# **Annex 1 to Submission by North Somerset Council in respect of Action point 19 ISH 5 -Environmental matters**

## **March 2021**

Following receipt of the cross-sectional details of the proposed Trinity footbridge North Somerset Council as Local Planning Authority considers that in relation to the impacts of overbearing impact and adverse visual impact these may be slightly less severe than we had feared previously

Shadow Study

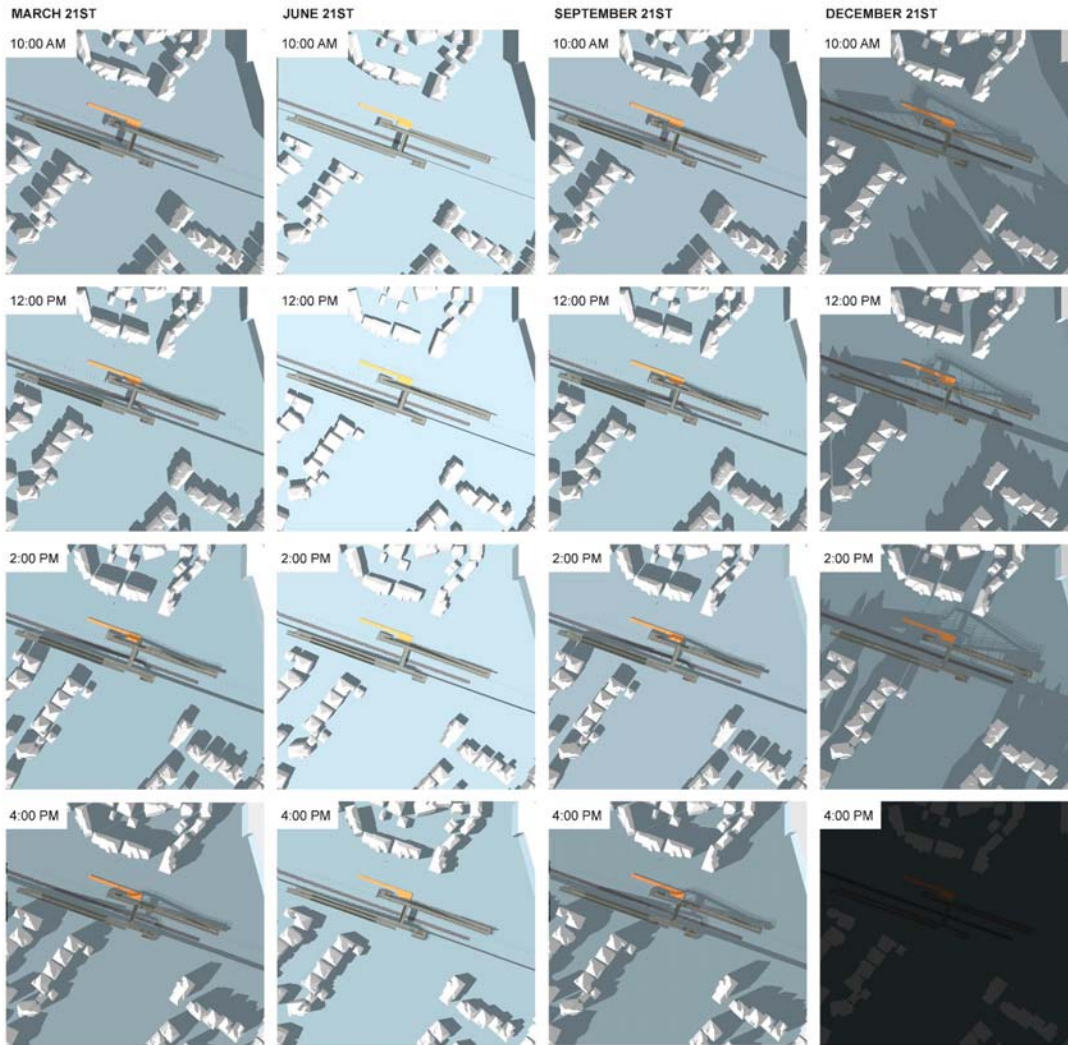
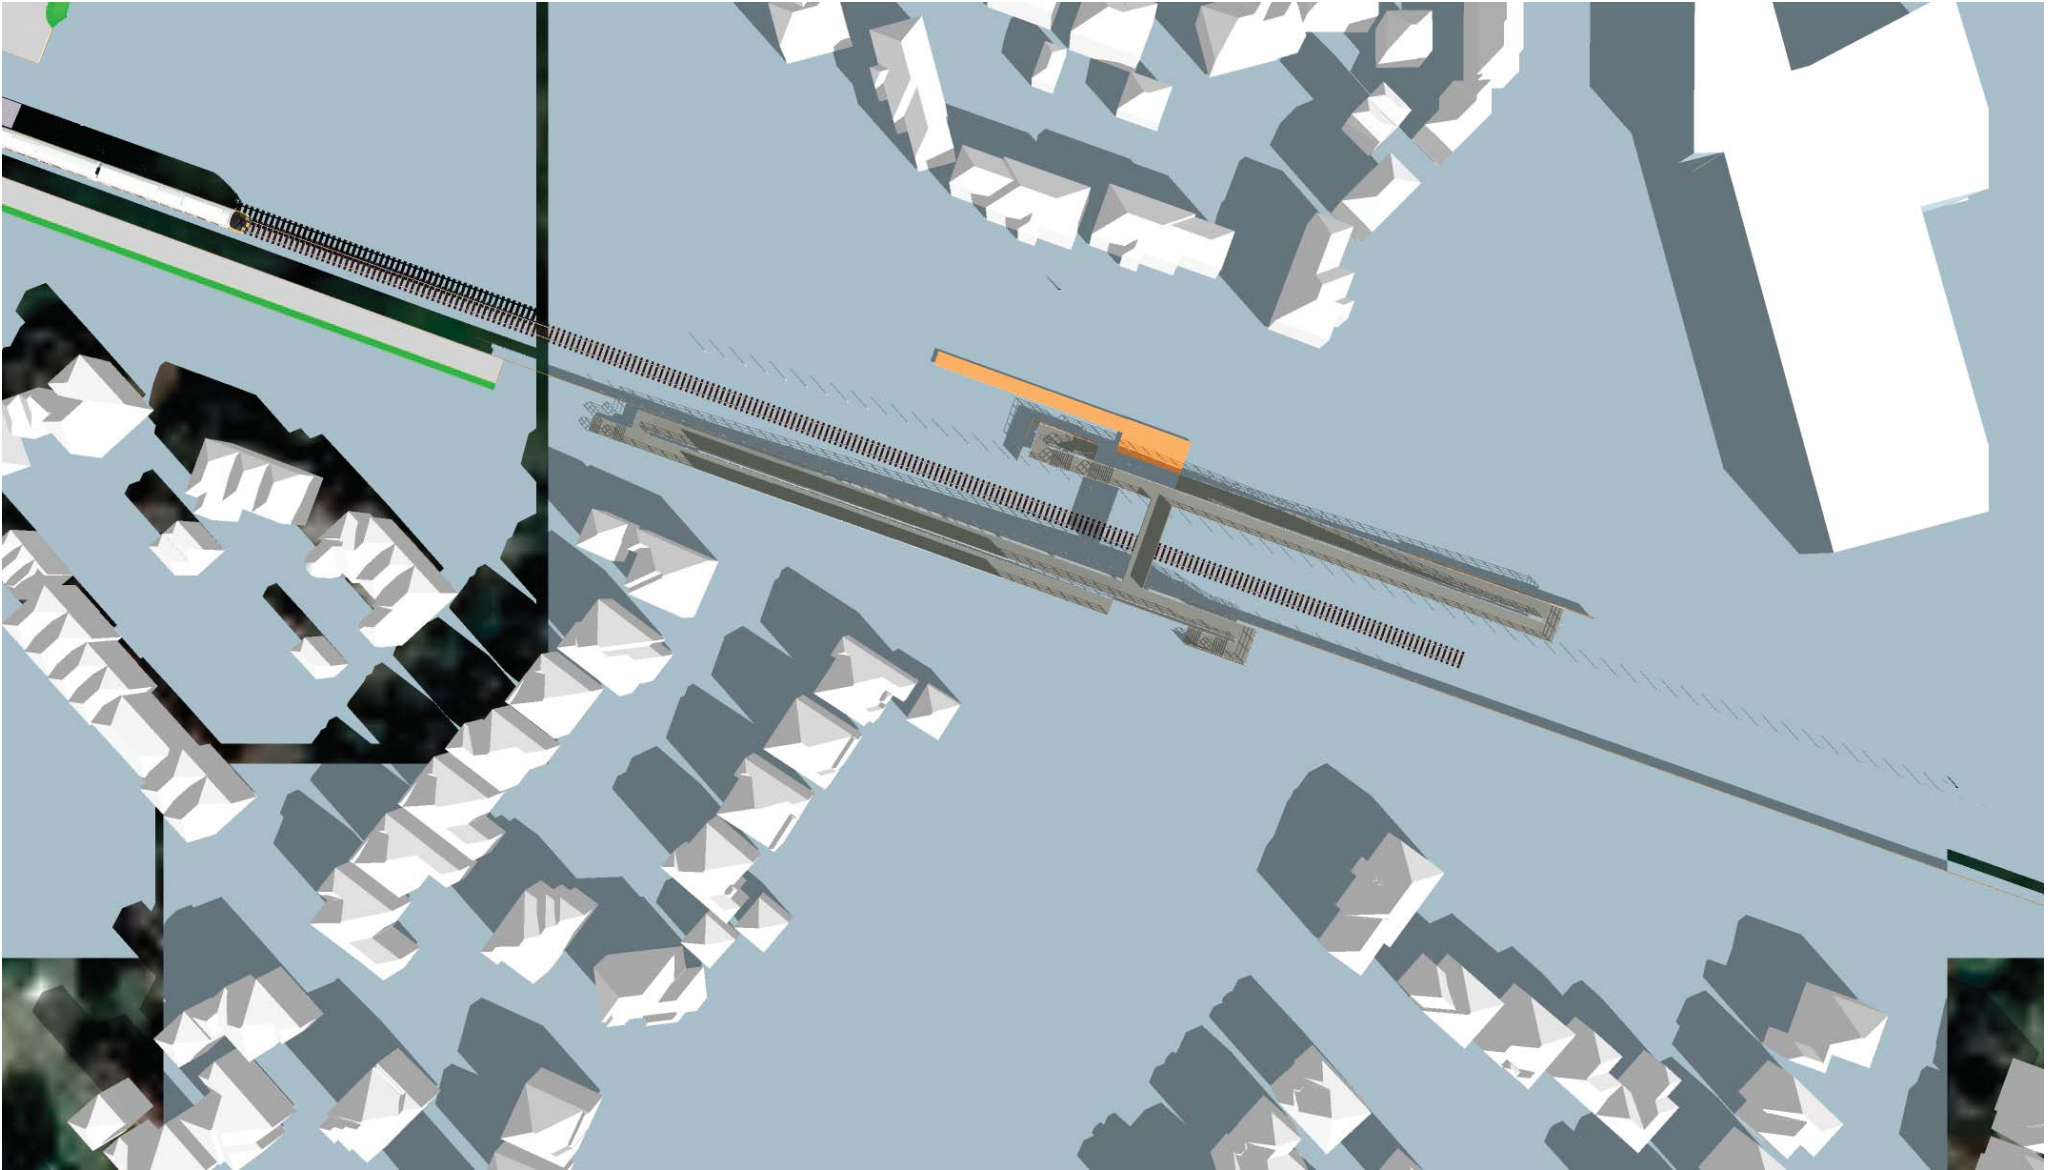
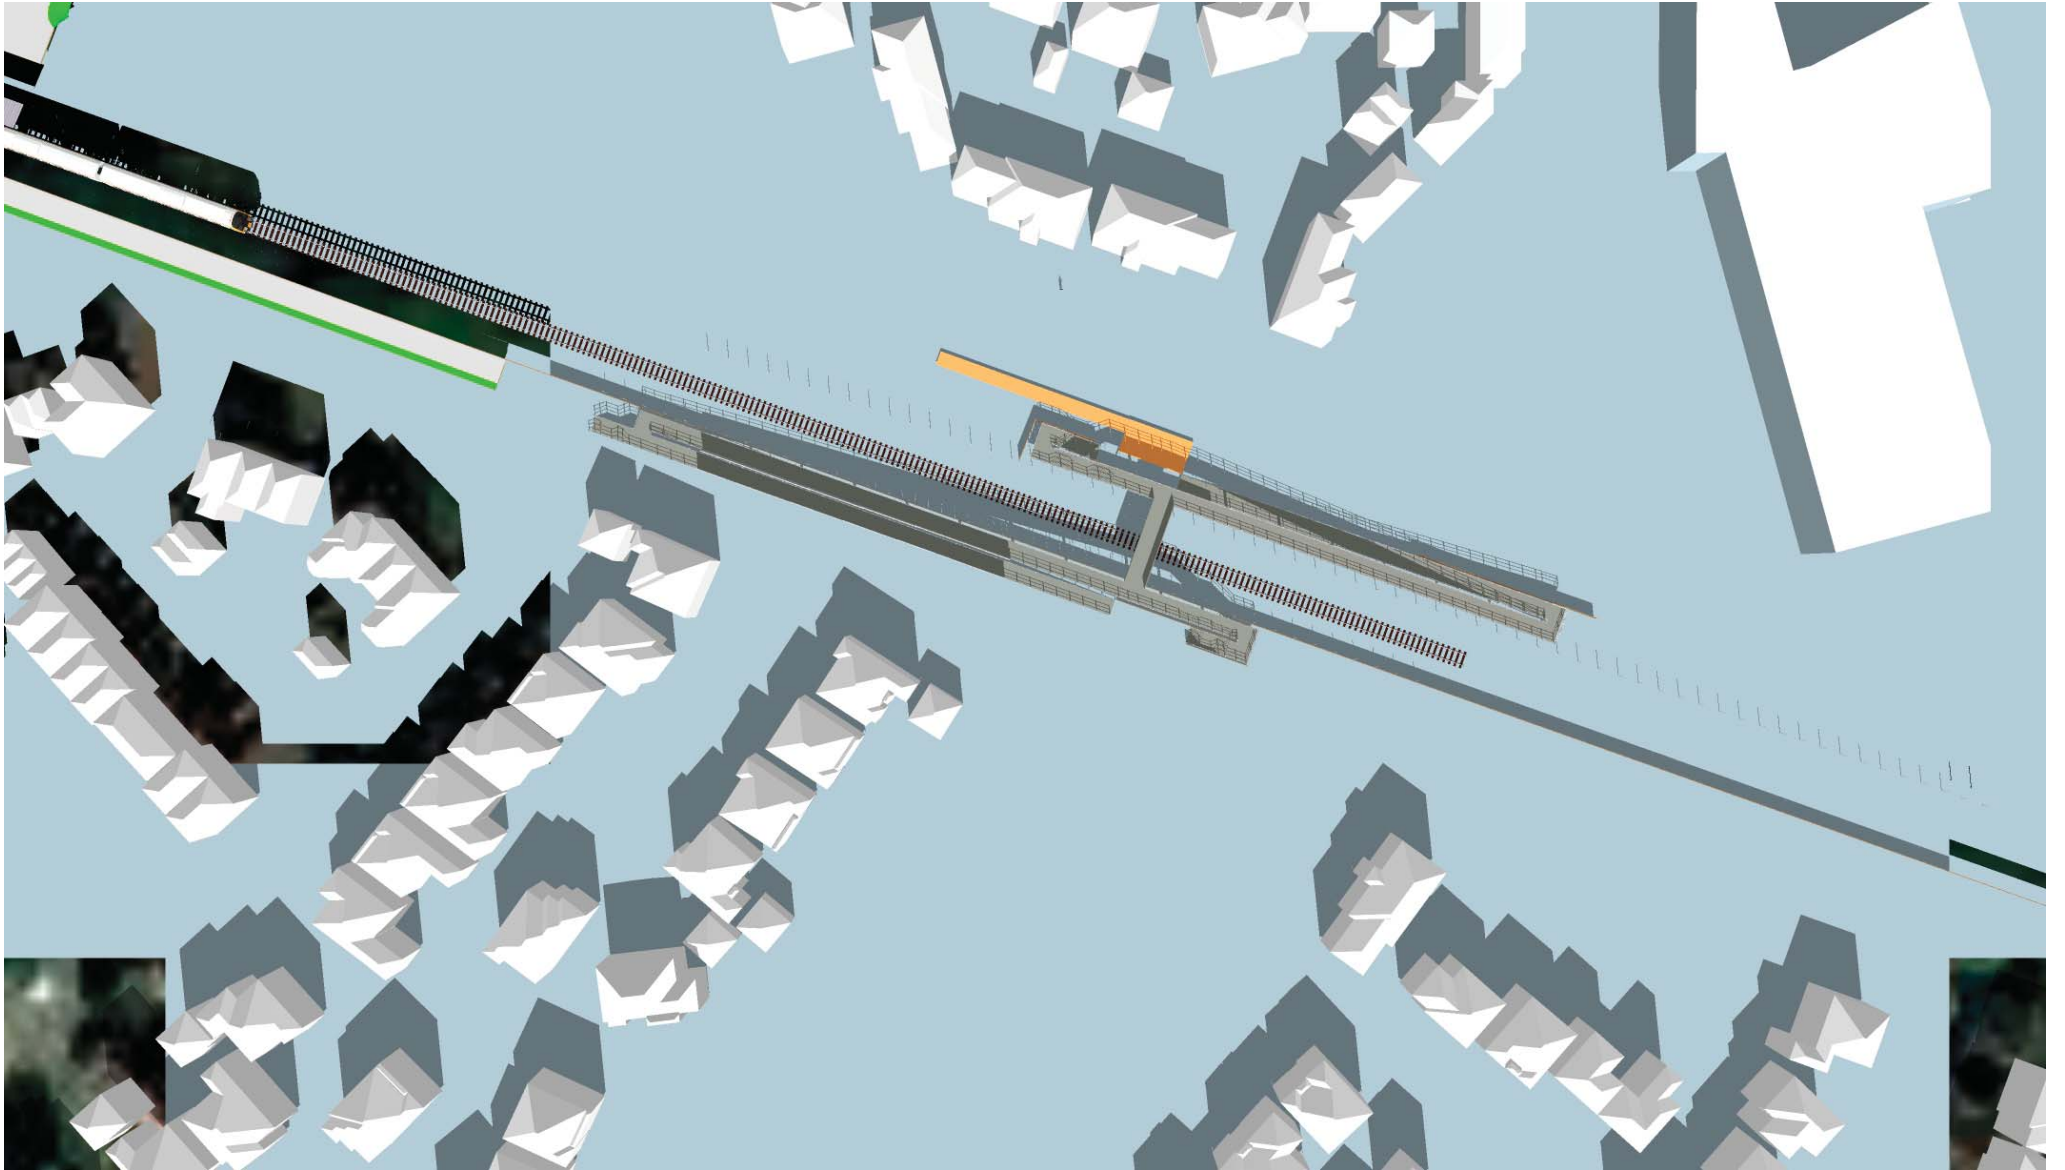
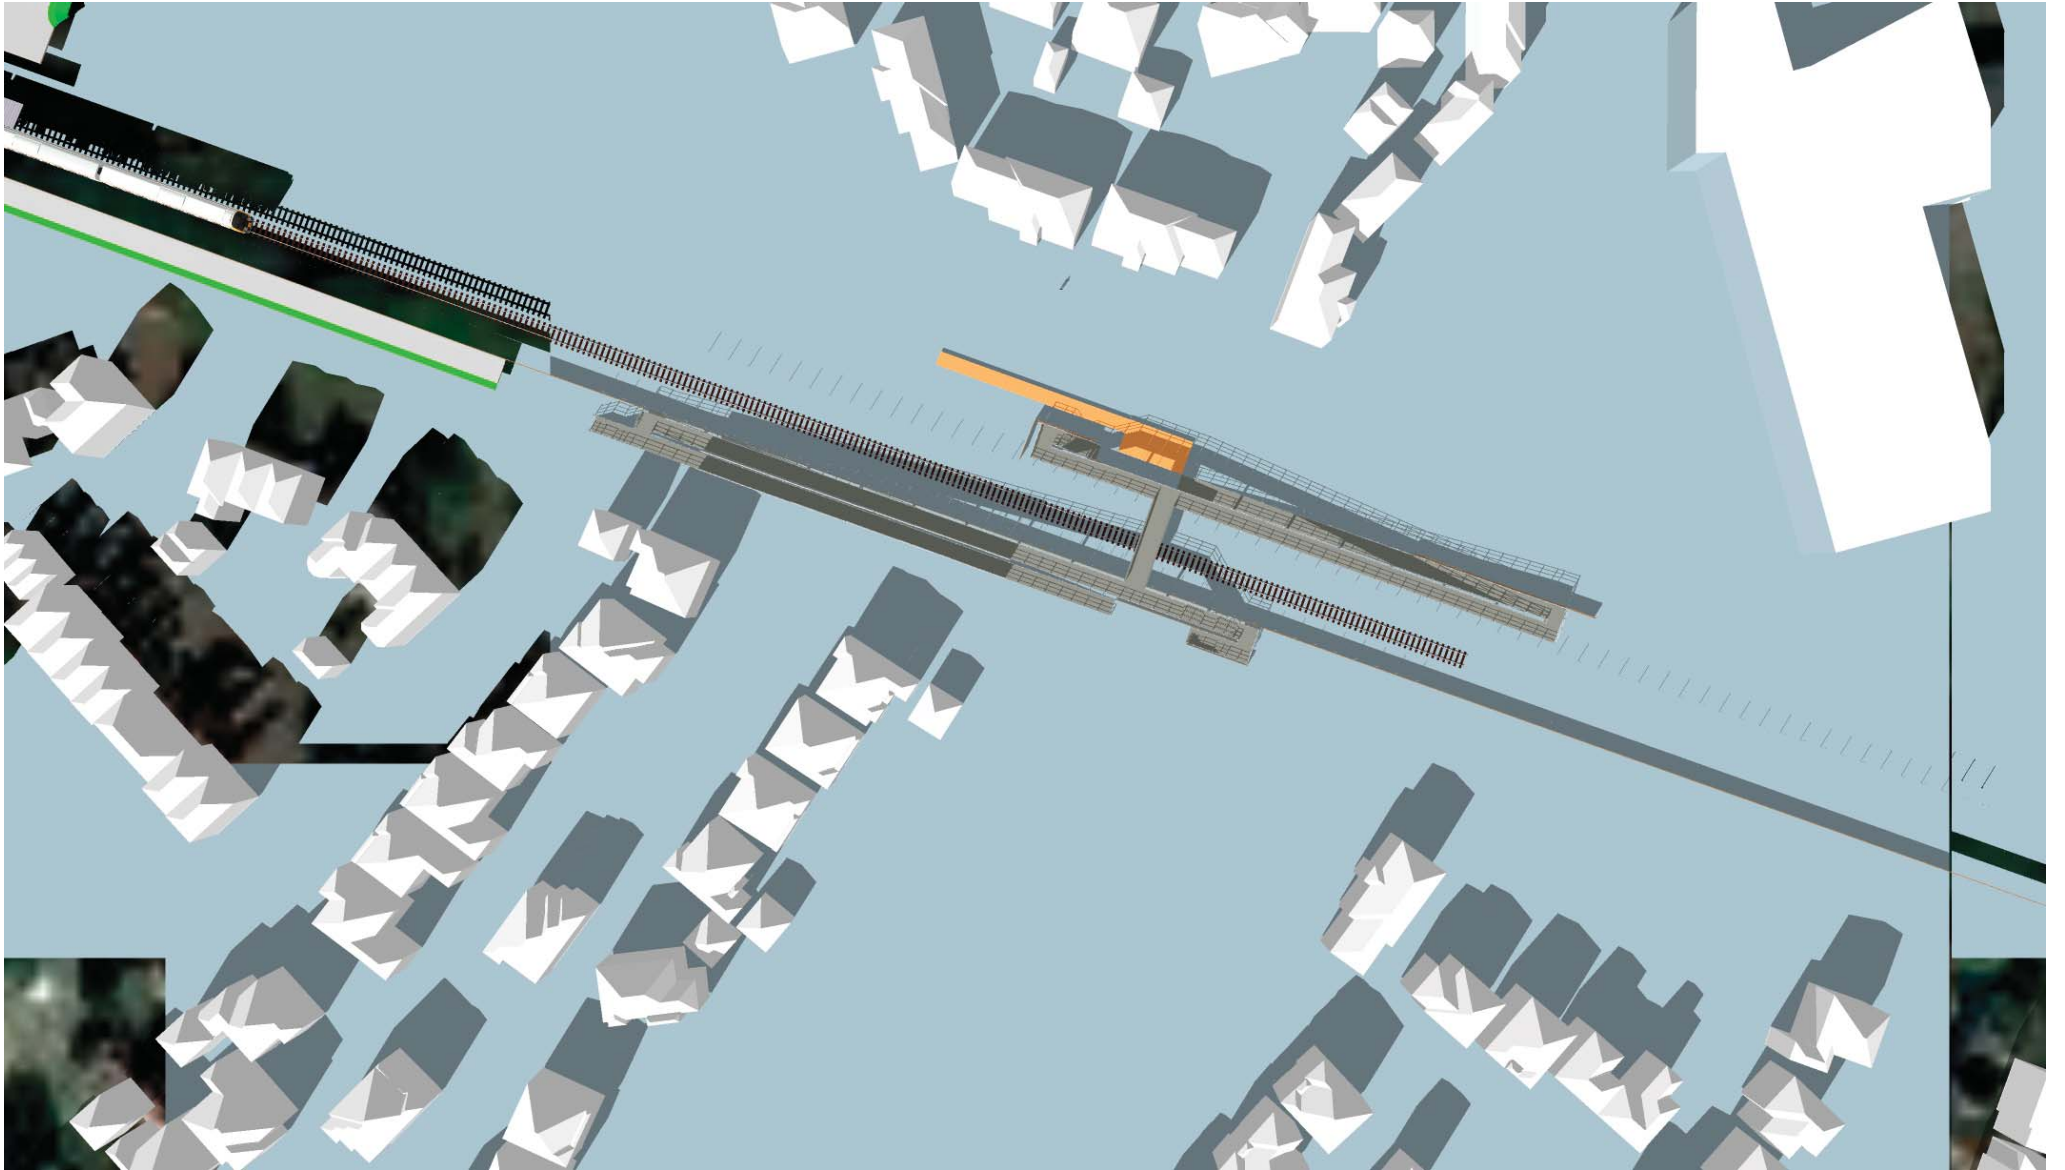
Following receipt of the shadow diagrams it is now easier to assess the impacts that these structures will have on surrounding properties.

The study presents shade impact graphics at 10:00am, 12:00am, 2:00pm and 4:00pm during Spring Equinox, Summer Solstice, Autumn Equinox and Winter Solstice. We consider that this provides sufficient information. From this information, it appears that the footbridge structures have the *potential* to overshadow properties along Tansy Lane (No 9, 11, 15 in particular) rather than properties to the south of the bridge.

From these graphics, it appears that these structures would have no impact at most times and periods of the year on these properties, except for the Winter Solstice
